**Planning Department
Transportation Development Services Section**

Re: Certification Submittal for Certificate of Occupancy for
Leyba Body Shop, 130 Tennessee NE
Architect's Stamp dated 10-19-12 (K19-D146)
Certification dated 2-03-14

TRAFFIC CIRCULATION LAYOUT

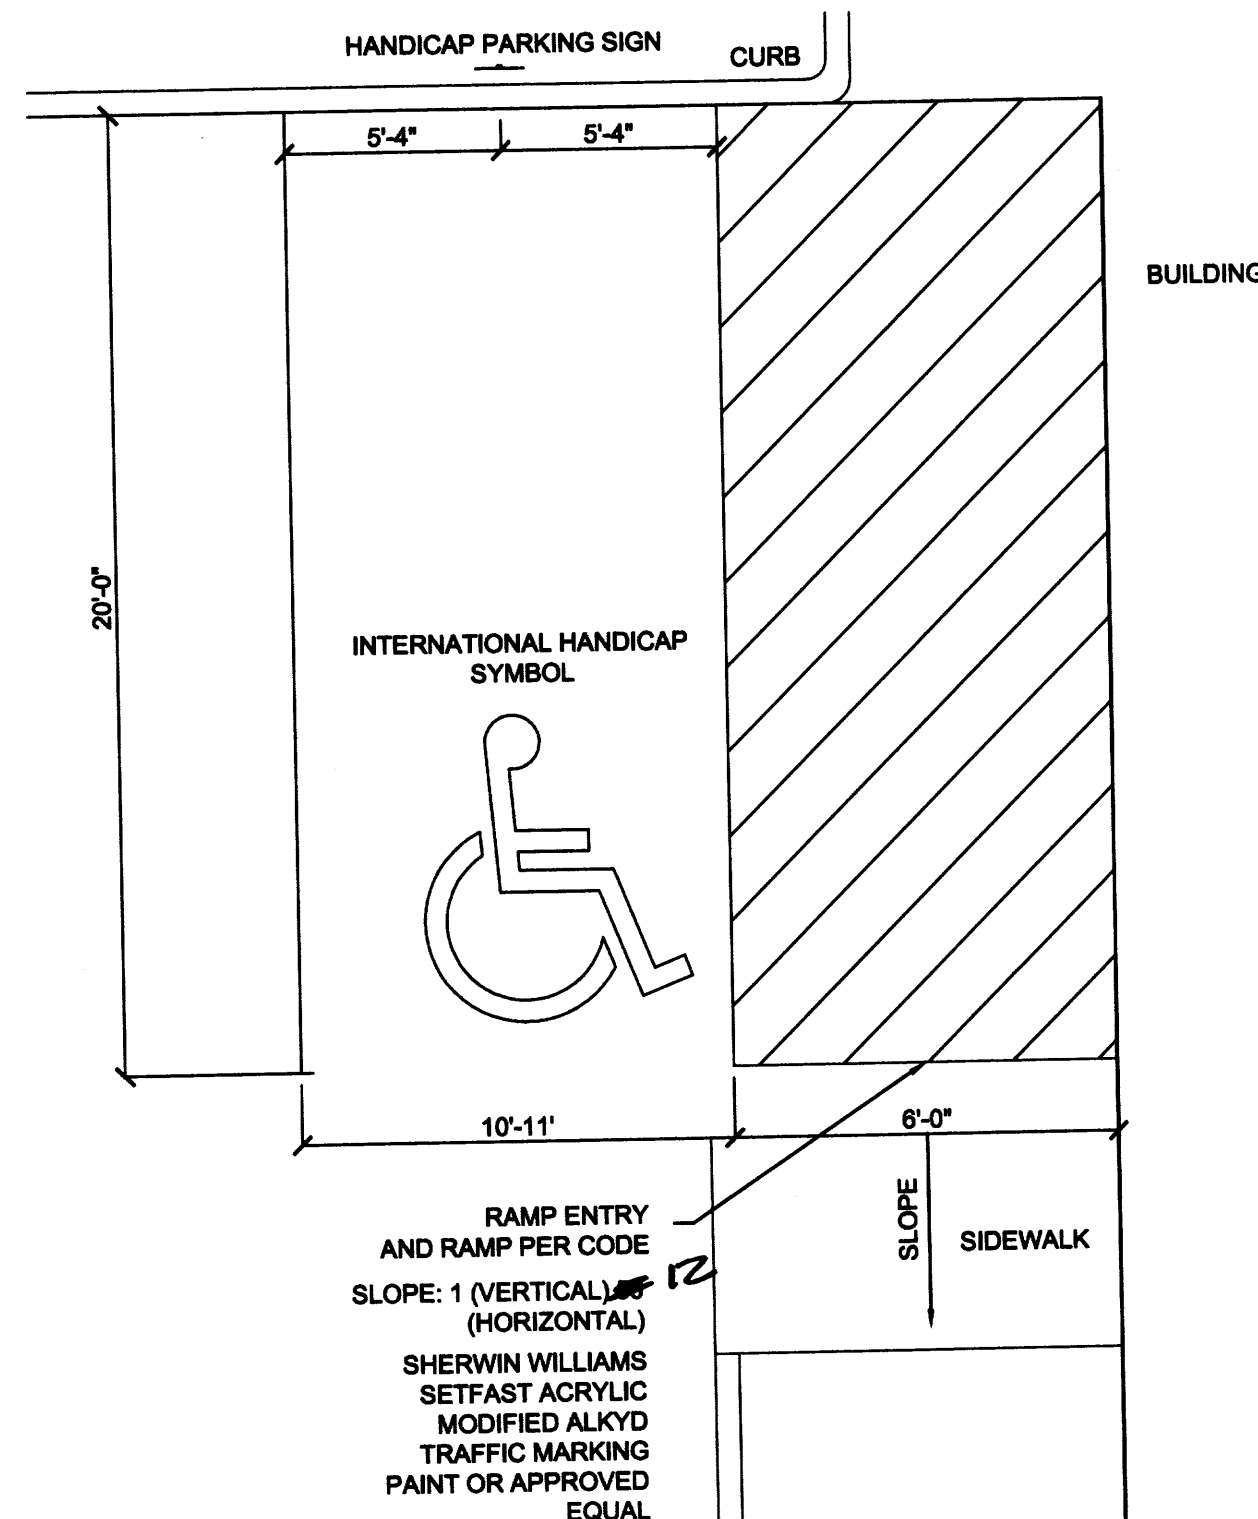
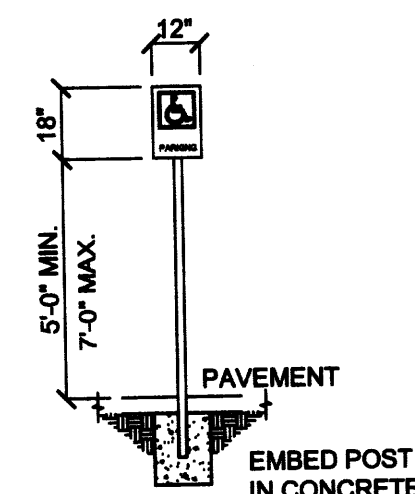
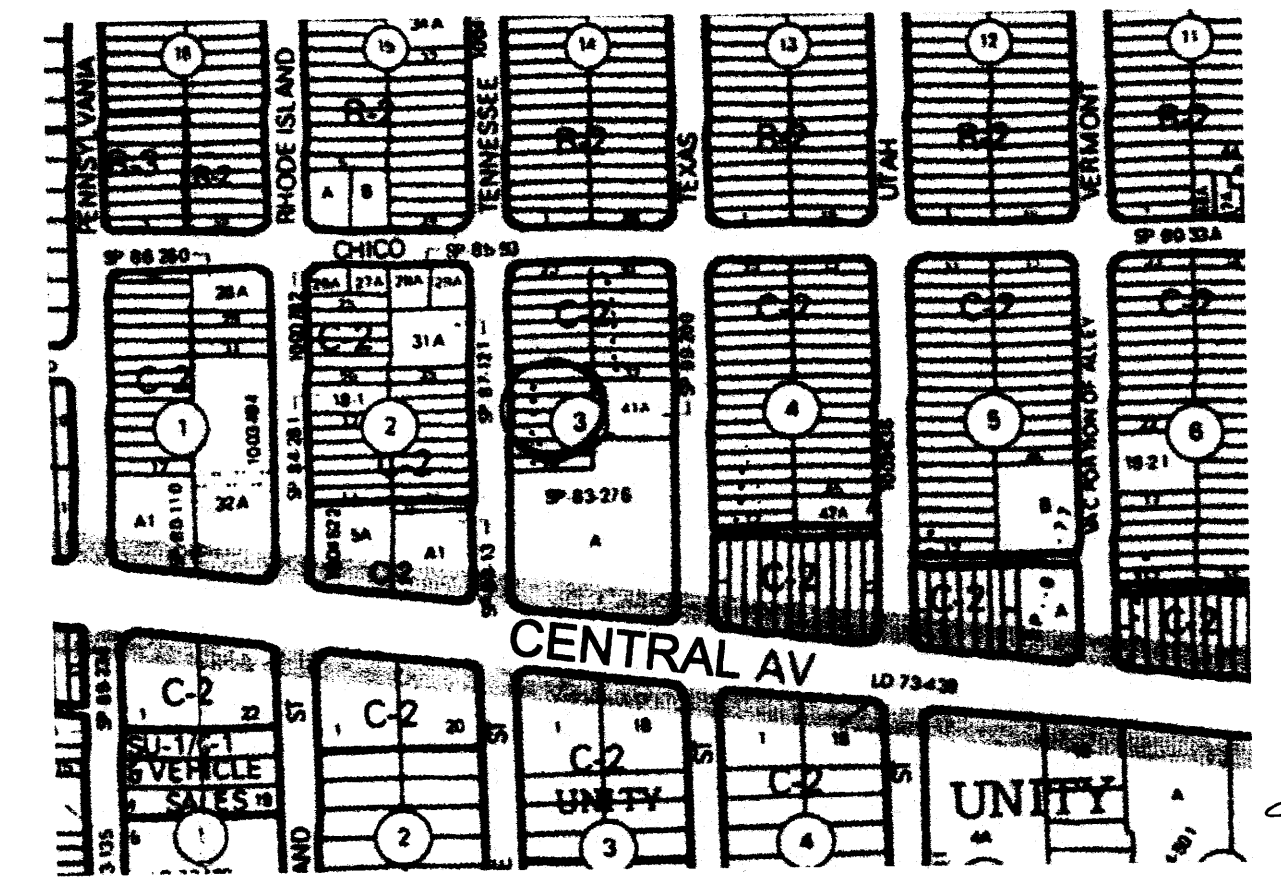
- The stripped pedestrian access aisle provided from the sidewalk to the building entry must be removed. The stripped pedestrian access aisle poses a risk to the pedestrian walking behind the ADA parking stall.

- A 5'-0' long sidewalk transition needs to be provided to the existing 3'-0' sidewalk on the South end of the property.
- The motorcycle parking stall must be stripped as called out on the site plan
- The ADA van accessible parking stall must include van accessible signage below the ADA signage. The ADA signage in parking lot must be a minimum of 60" from the bottom of the sign to the ground or parking surface.
- The ADA access aisle should have diagonal striping as shown on the site plan.
- The fence fronting the property needs to be reflected on the site plan with the setback distance from the face curb.
- A revised final traffic certification will be required.
